31 March 2021

## **Re: St John of God Richmond Hospital Redevelopment (SSD-10394) Response to Submissions**

Lew Short | Director  
**Blackash Bushfire Consulting**

Figure 6 Detailed Slope Map (updated showing relocated Wellness Centre)

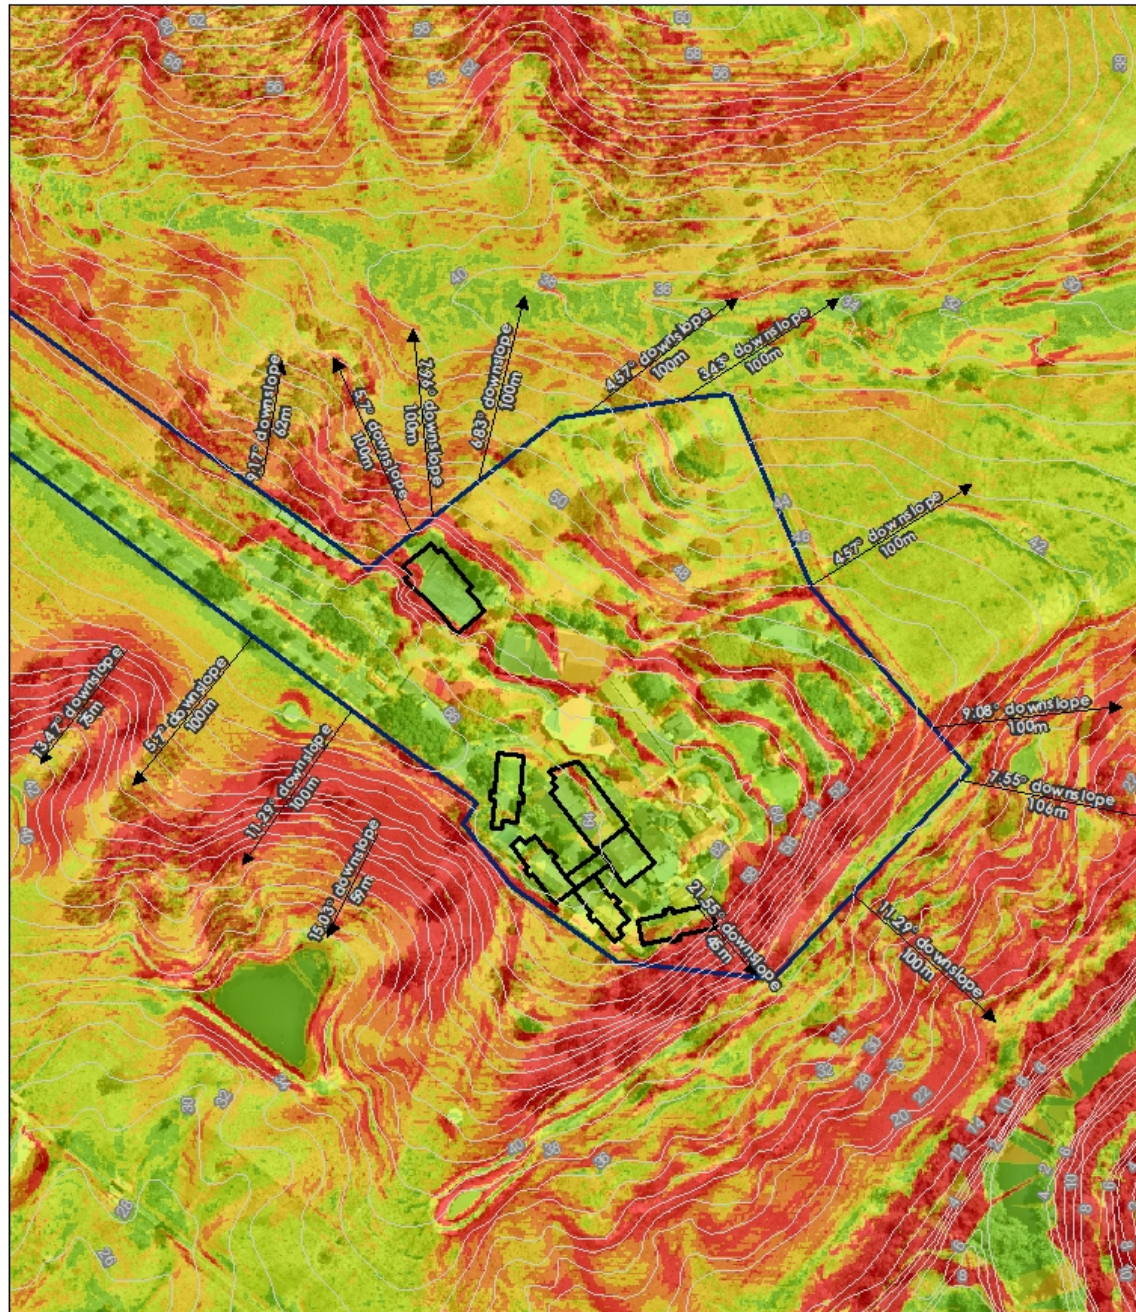
- *the concerns raised by the NSW Rural Fire Service (RFS) are to be further investigated as the Residential Pavilions, Garden Pavilions and Wellness Centre are still non-compliant with the requirements of Table A1.12.1 of Planning for Bushfire Protection 2019. Additionally, the buildings should be located outside of the Flame Zone.*

The Wellness Centre is not a SFPP development. The Wellness Centre does not provide accommodation. The BCA Design Compliance Report (BCA Report) by MBC Group (dated 21 March 2020) notes that the Wellness Centre is a Class 9b structure being a public assembly building as shown in Table 1. As such, the Wellness Centre must comply with the aim and objective of PBP. Based on previous discussion with the RFS, the Wellness Centre was moved out of the Flame Zone. However, the structure is designed to meet Flame

Zone construction requirements in accordance with AS3959 and provides a defendable space around the building. In terms of the Objectives of PBP (p. 10), the Wellness Centre

- affords buildings and their occupants protection from exposure to a bushfire by Flame Zone construction. The use of the building can be controlled through the Emergency Management and Evacuation Plan including not utilisation on declared Catastrophic fire weather days.
- provides for a defendable space to be located around buildings;
- provide appropriate separation between a hazard and buildings which, in combination with other measures, prevent the likely fire spread to buildings;
- ensure that appropriate operational access and egress for emergency service personnel and occupants is available;
- provide for ongoing management and maintenance of BPMs; and
- ensure that utility services are adequate to meet the needs of firefighters.
